From: Tom Errico <thomas.errico@tylin.com>
To: Jean Fraser <JF@portlandmaine.gov>
CC: David Margolis-Pineo <DMP@portlandmaine.gov>, Katherine Earley <KAS@portlandmaine.gov>, Jeff Tarling <JST@portlandmaine.gov>, "JeremiahBartlett" <JBartlett@portlandmaine.gov>
Date: 1/23/2014 9:51 AM
Subject: Capisic Pond Improvements Project

Jean - I have reviewed the proposed plans and request that the following information be provided for the project.

**C-101**

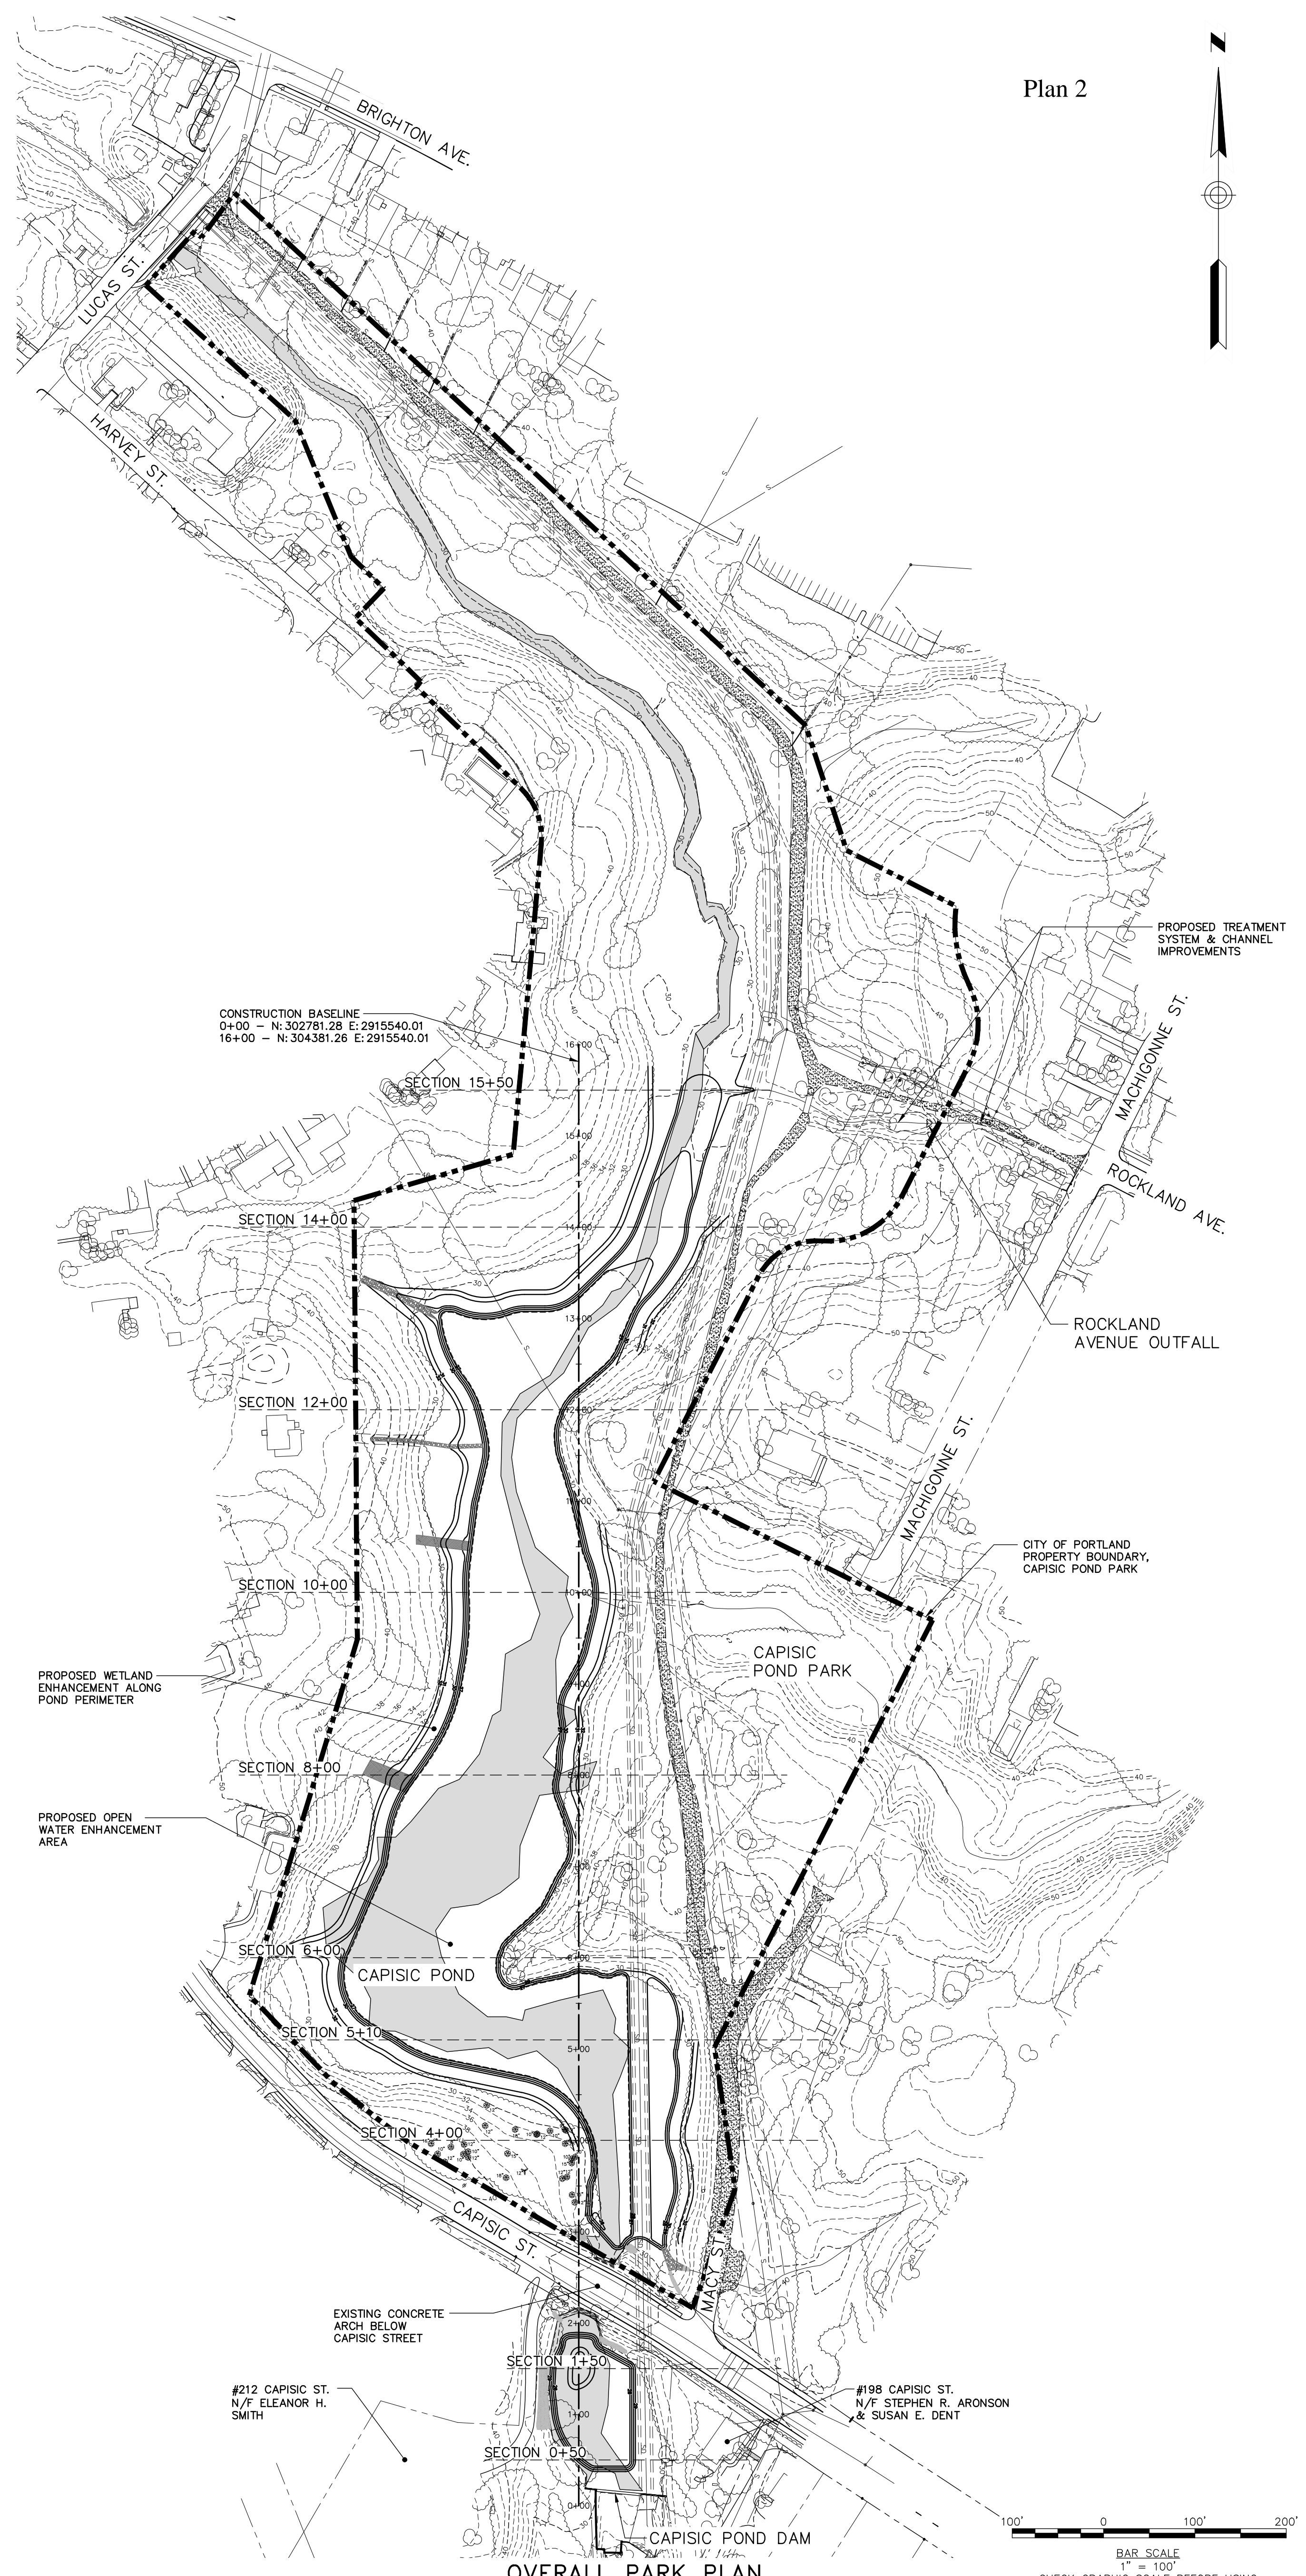
* Sight distance measurements shall be provided for proposed temporary driveways with discussion on meeting City standards.

* A proposed truck routing plan shall be documented. It is my understanding that it is likely that trucks will be destined to the City of Westbrook via Brighton Avenue. Accordingly, it seems reasonable that the routing consist of travel along Capisic Street to Brighton Avenue. I would suggest that truck activity avoid peak drop-off and pick-up times at Breakwater School. Also, provisions to ensure that vehicles are cleaned prior to entering the public street system should be included.
